Town & Country Planning Act 1990 (as amended)
Town and Country Planning (Development Management Procedure) (England) Order 2015
Approval of details reserved by conditions imposed under P/107/16/PL relating to conditions 3-
surface water drainage, 4-schedule of materials & finishes, 5-landscape scheme, 6-screen
wall/fence details, 8-site set up during construction, 10-storage of waste & recycling details , 11-
placement of 2 No. nesting opportunities for birds & 14-external lighting details.
7 Webb Close Pagham,,

Notification regarding the above application:

Condition Number 10

17017-103^A

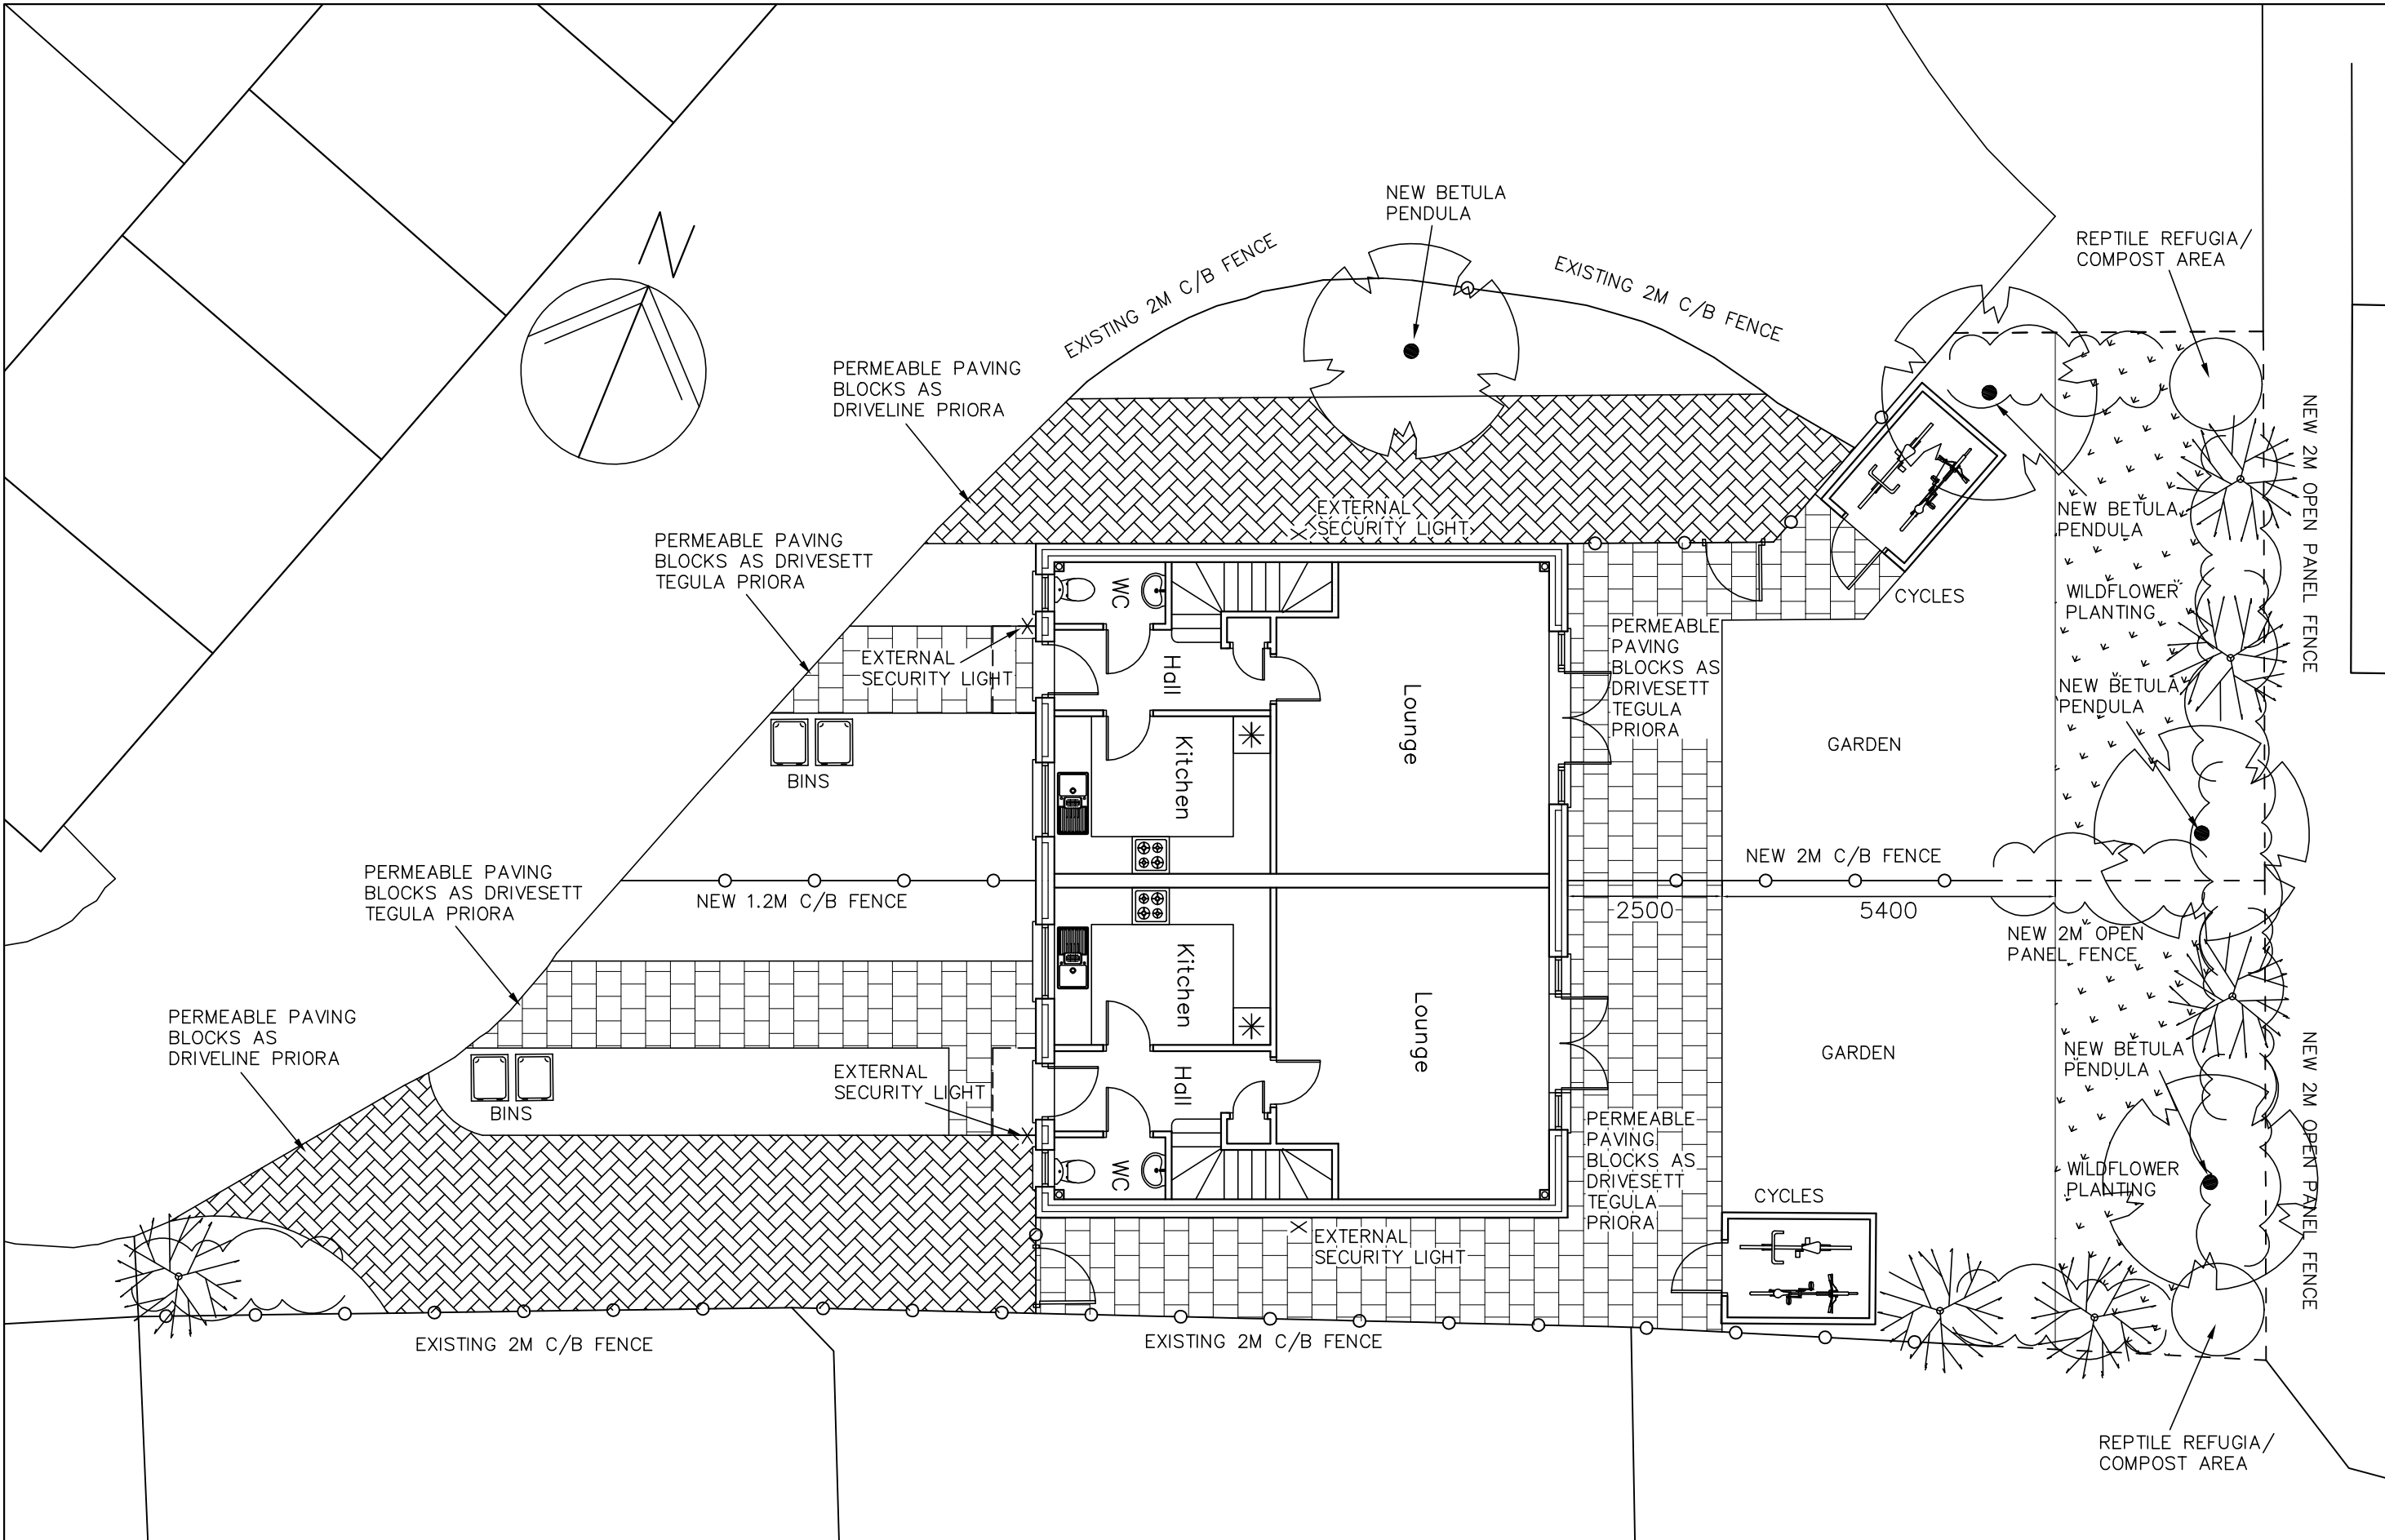
The submitted details in respect of the storage of waste and recycling namely the siting of the bins as shown on Drawing 17017-103 Rev A are considered to provide an acceptable scheme and satisfy the requirements of the condition.

The condition is therefore fully discharged insofar as the submission of details relates and on the understanding that the bin storage locations will be provided in accordance with the agreed details and thereafter permanently retained.
